WELWYN HATFIELD COUNCIL – DEVELOPMENT CONTROL
DELEGATED REPORT

| APPLICATION No: | S6/2007/543/FP |

The application seeks to demolish the existing detached chalet style bungalow with pitched roof garages and replace it with a new detached two storey dwelling with attached triple garage.

client	Stuart Anderson RAM HomesLtd		
project	New House, Dormers 53 Kentish Lane Brookman's Park, Herts		
drawing	EXISTING OUTLINE & PROPOSED HOUSE		
date	scale	drawn by	
03/07	1:100 @ A1		
drg.no.	rev.		
SK 01

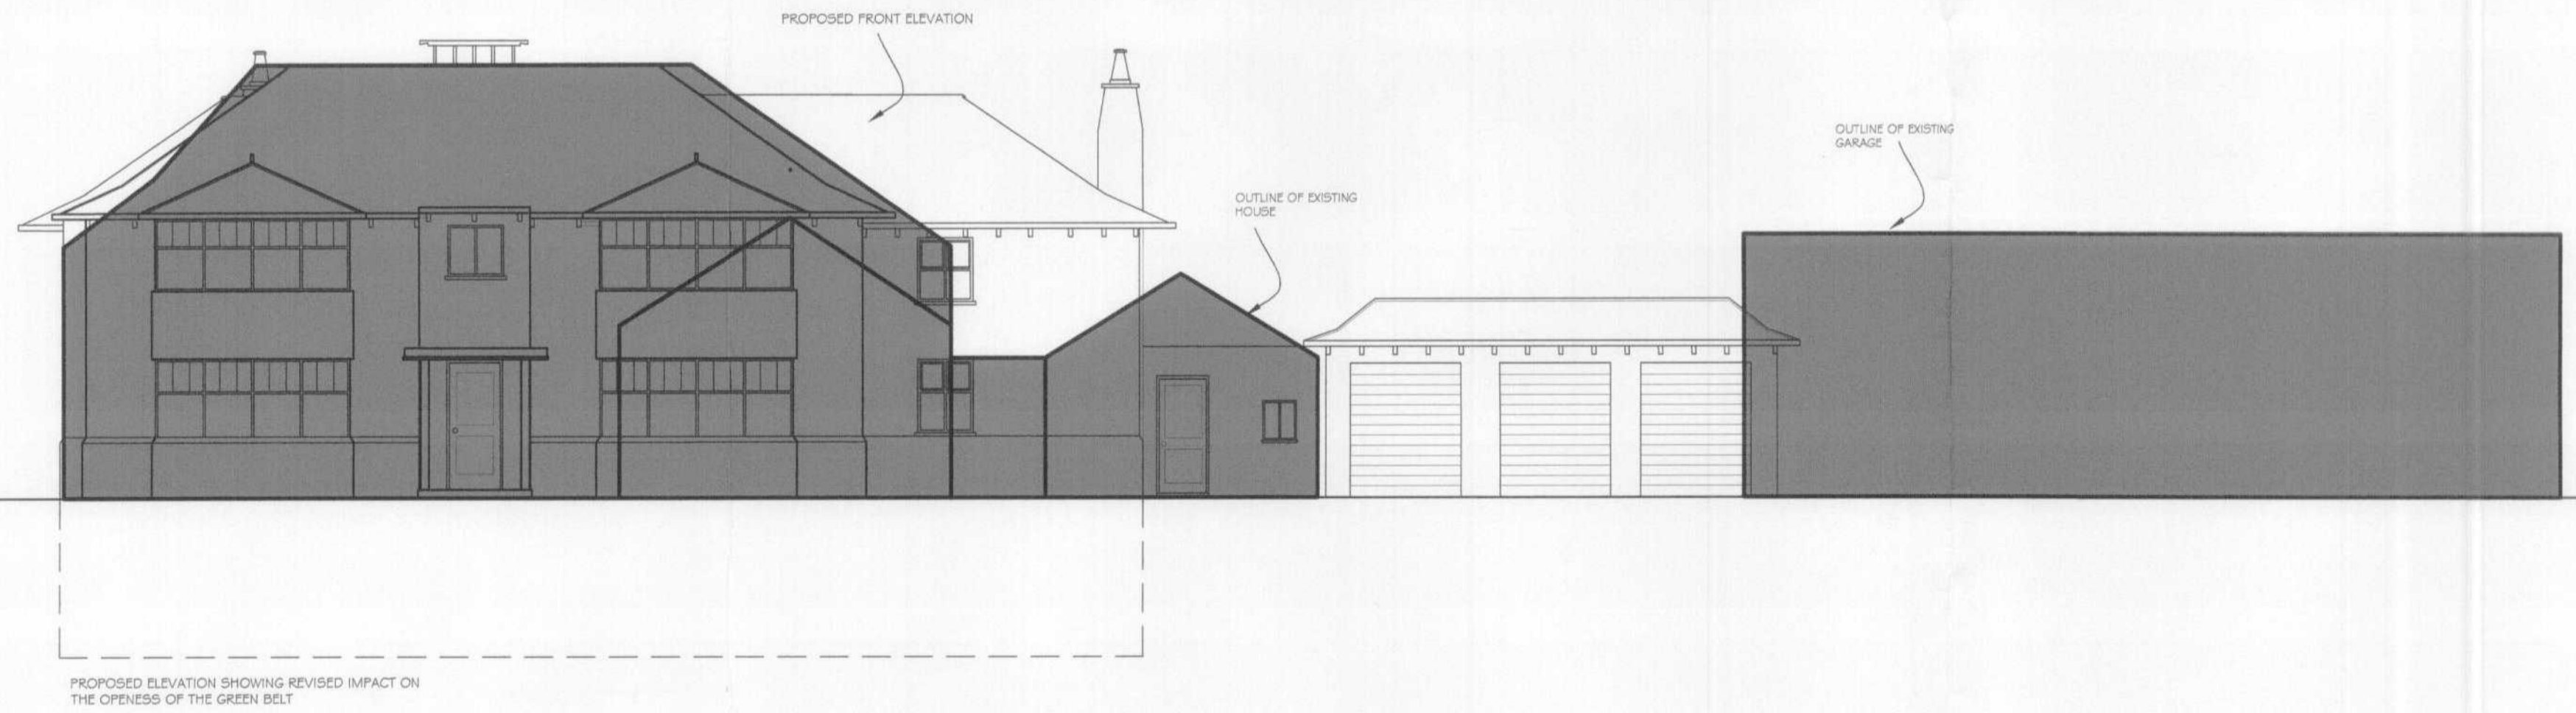
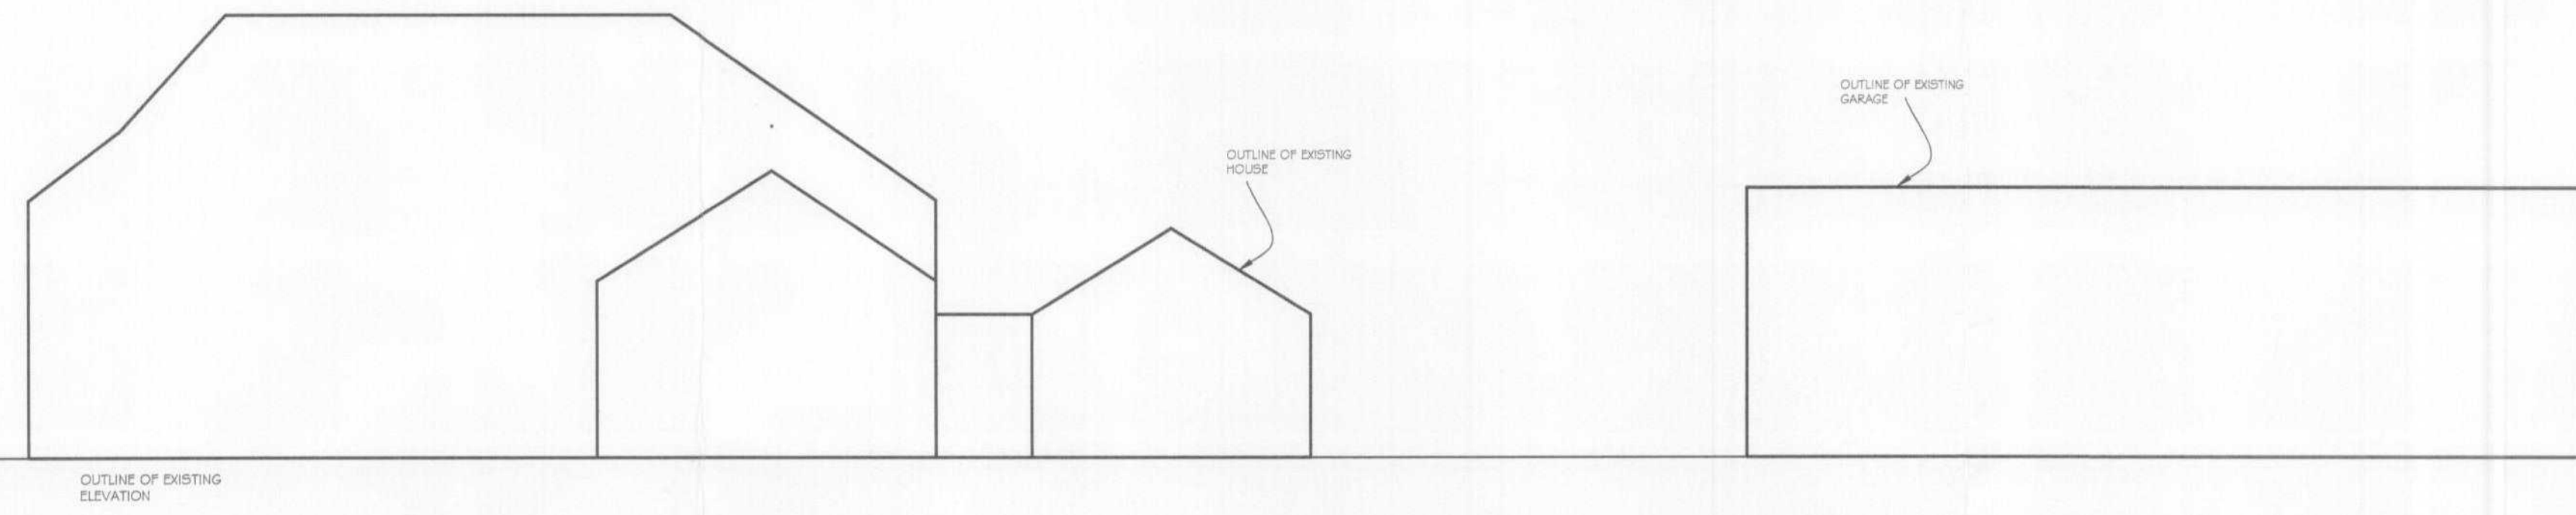
A numerical volume calculation and comparison would be difficult to calculate, although from a visual inspection and assessment of the drawings it is clear that the additional floorspace has resulted in a significant increase in volume in respect to the existing dwelling, particularly above ground floor level.

From this visual assessment, it is considered the proposal will have a far greater visual impact on the openness of the Green Belt than either the original or existing dwelling, due to its greater bulk and mass. This view is reached taking into account that the existing dwelling has, for the main part, a low eaves level with dormer windows located in the hipped ends, whereas the proposal is more alike to a full height two storey building.

project	DORMERS, KENTISH LANE BROOKMAN'S PARK, HERTS.	date	03/ 07	scale	1:100	drawn by	me
drawing	PROPOSED BASEMENT PLAN	drwg. no	ELP - 01	rev

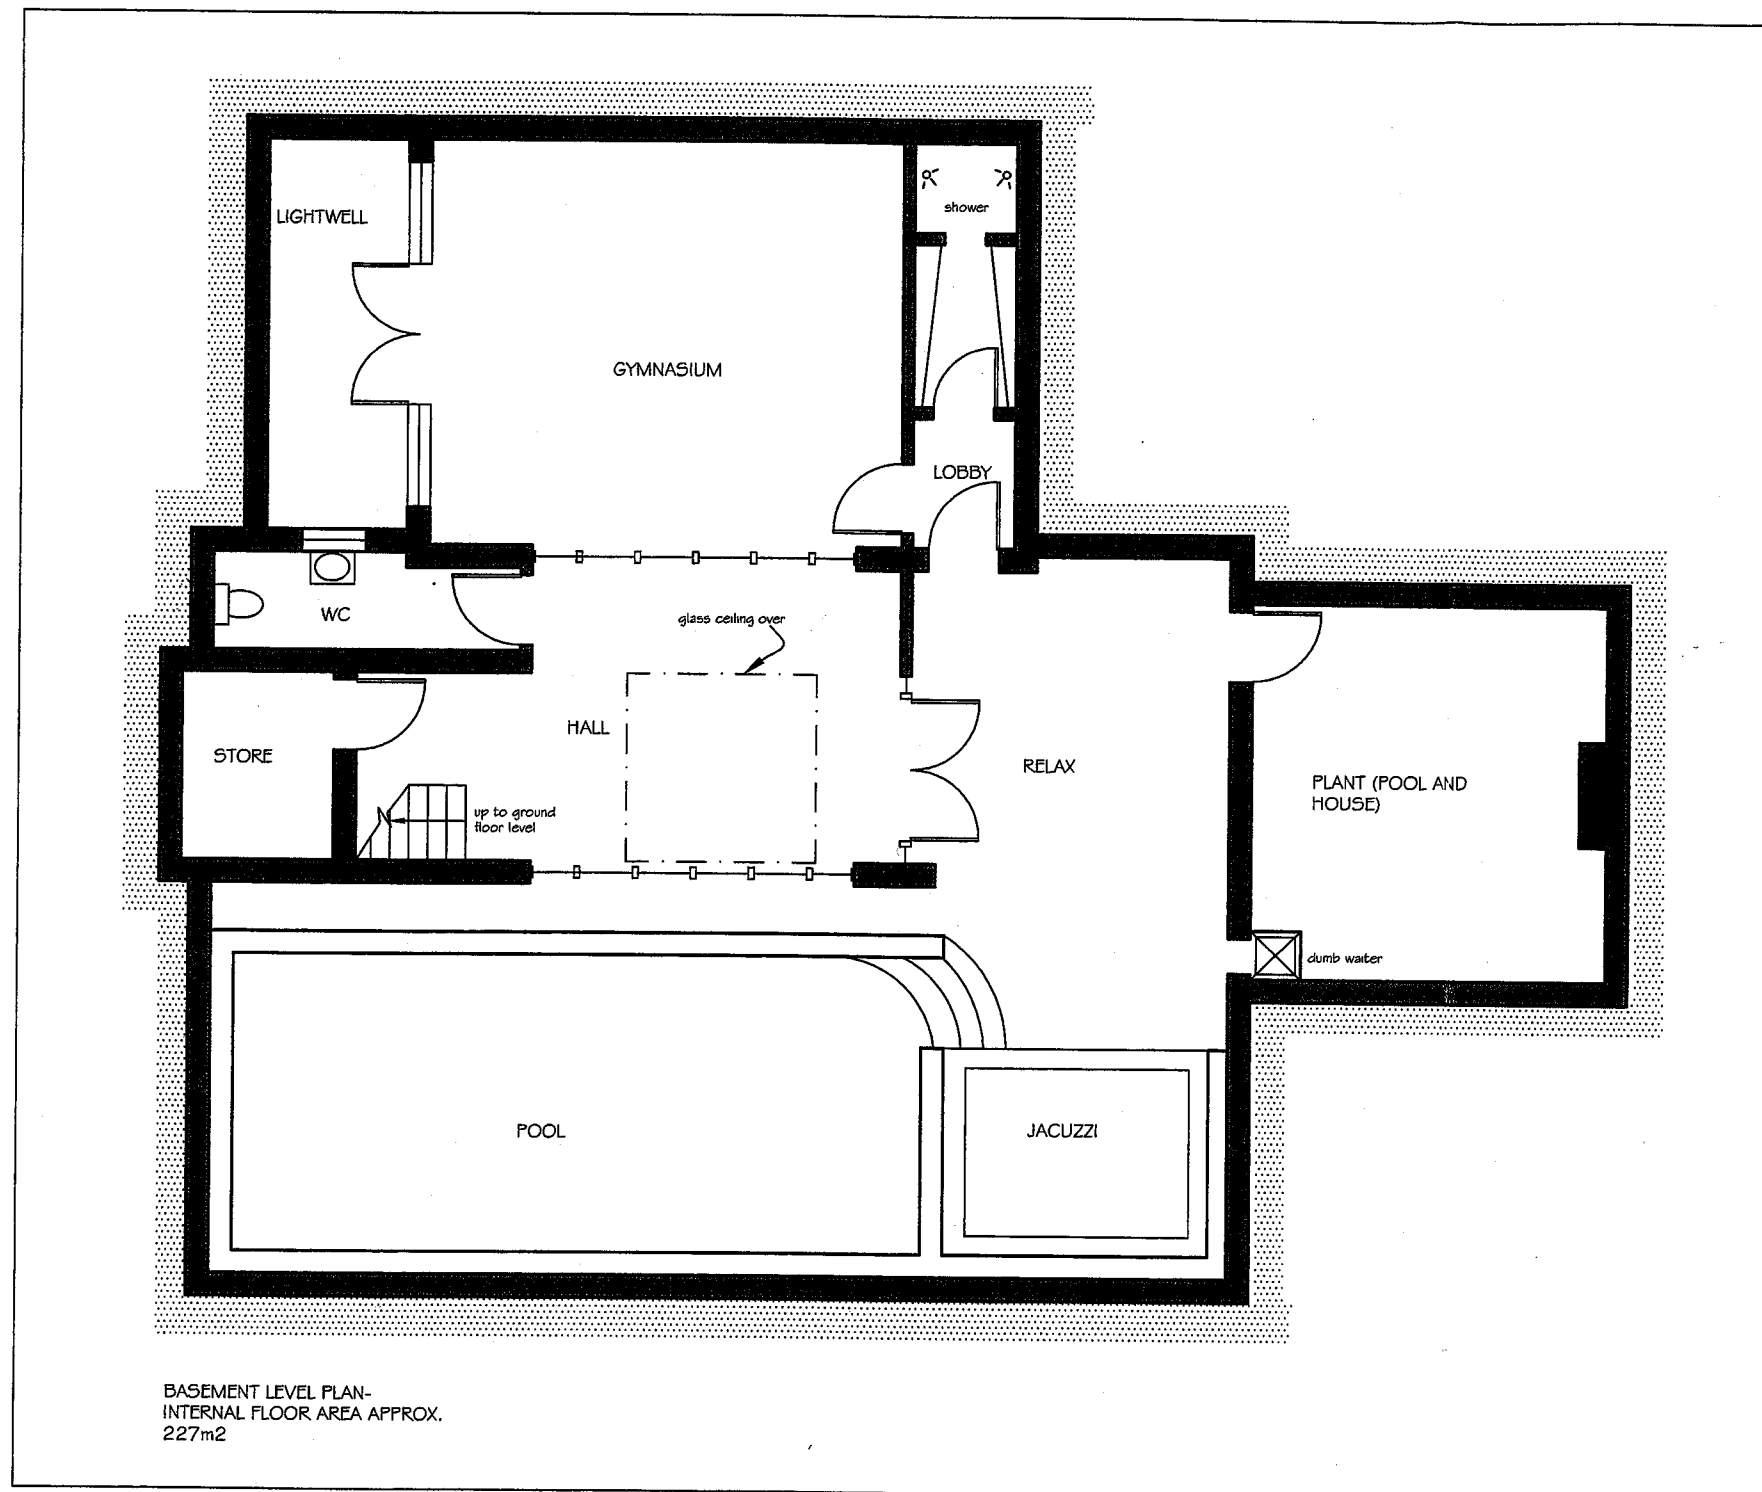
The application also proposes to include some additional 'lower level accommodation' to create leisure facilities such as a gymnasium, jacuzzi and swimming pool. However, parts of this particular area are accommodated by natural light and as such it is questionable as to whether these would serve as additional floorspace. The natural light is provided by a lightswell to the south eastern section of the proposed building and by a roof lantern within the main roof of the dwelling.

project	DORMERS, KENTISH LANE BROOKMAN'S PARK, HERTS.	date	03/07	scale	1:100	drawn by	me
drawing	PROPOSED FIRST FLOOR PLAN	drwg. no	ELP - 03	rev

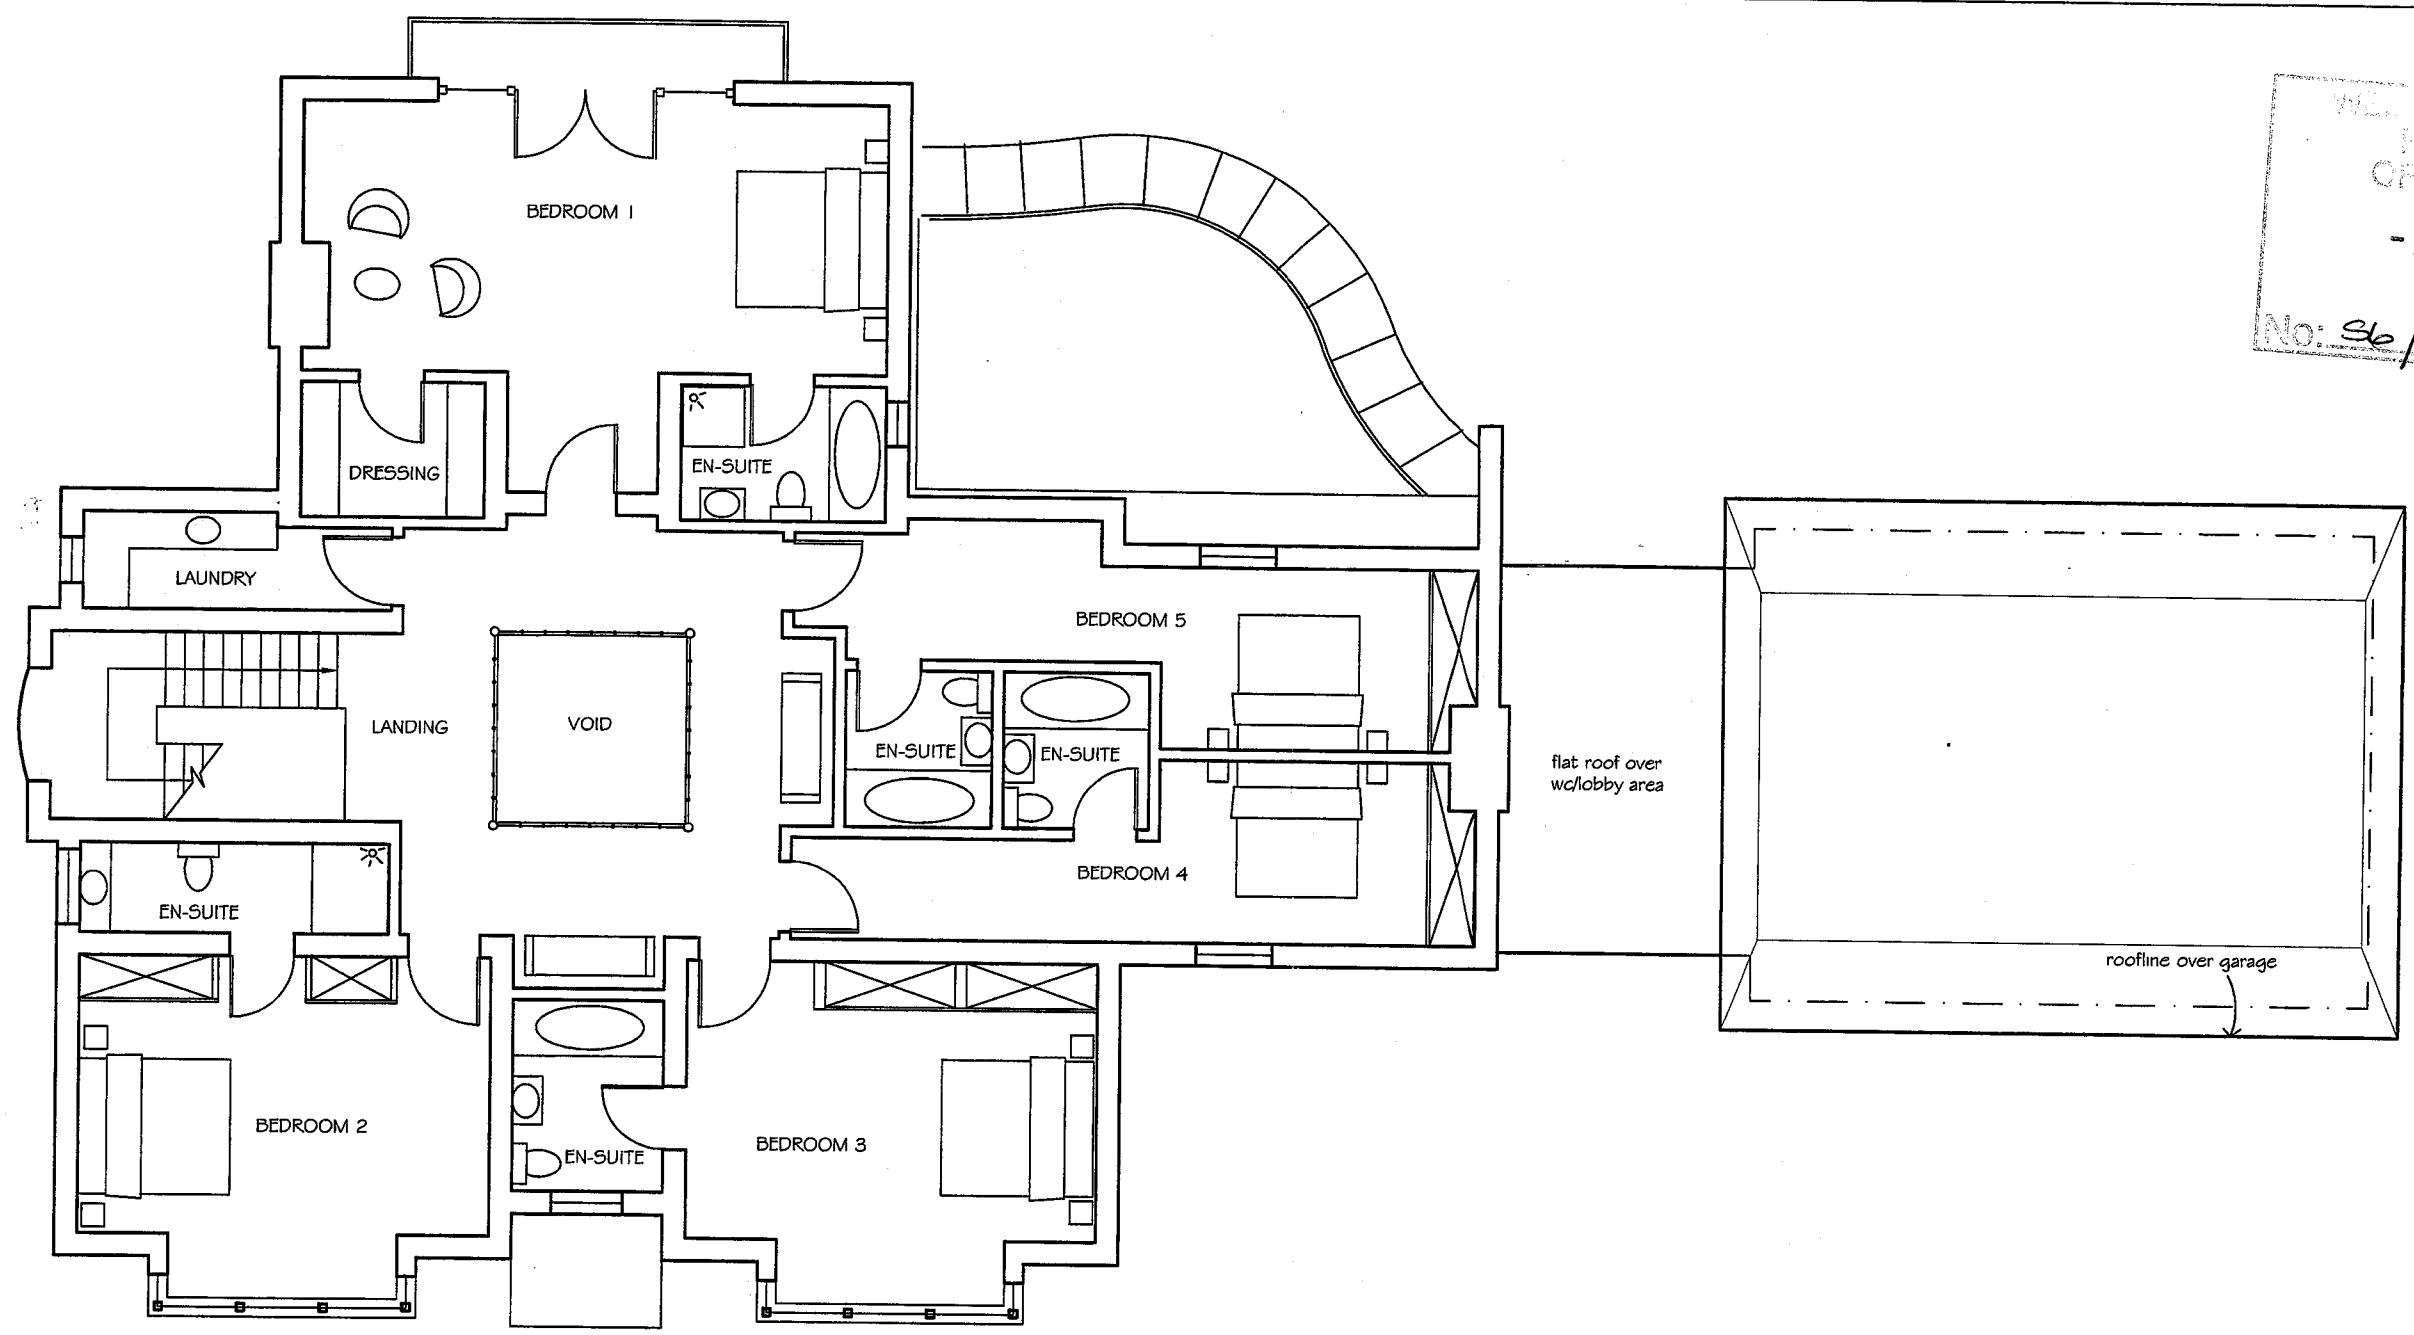
There would be three windows at first floor level in this elevation facing 51 Kentish Lane, however two would serve an ensuite and a laundry room and the third is for the stairwell. As the laundry room and ensuite room are non-habitable rooms a planning condition requiring these windows to be obscure glazed and non-opening below 1800mm could be attached to any permission to minimise the potential for overlooking. In addition, the proposed balcony to the rear elevation is not considered to create unacceptable overlooking due to the oblique angles and separation distances between properties.

In terms of height, the proposed dwelling is materially lower (approximately 0.6m) than the existing, however, the eaves height would be higher at approximately 5 metres rather than 4.5 metres, which increases the visual appearance of the building. Furthermore, additional bulk has been created at first floor level to the north eastern section of the building. In addition, the creation of a triple garage in replacement of the existing garage would create further bulk and mass despite the demolition of two existing garages (one is over 5 metres from the dwelling), as it would create an increase in the maximum width of the proposed dwelling. The existing separation distances between the two garages and reduced mass at first floor level currently serve as an important visual gap in promoting distant views to the surrounding countryside and a such maintaining these gaps would be desirable.
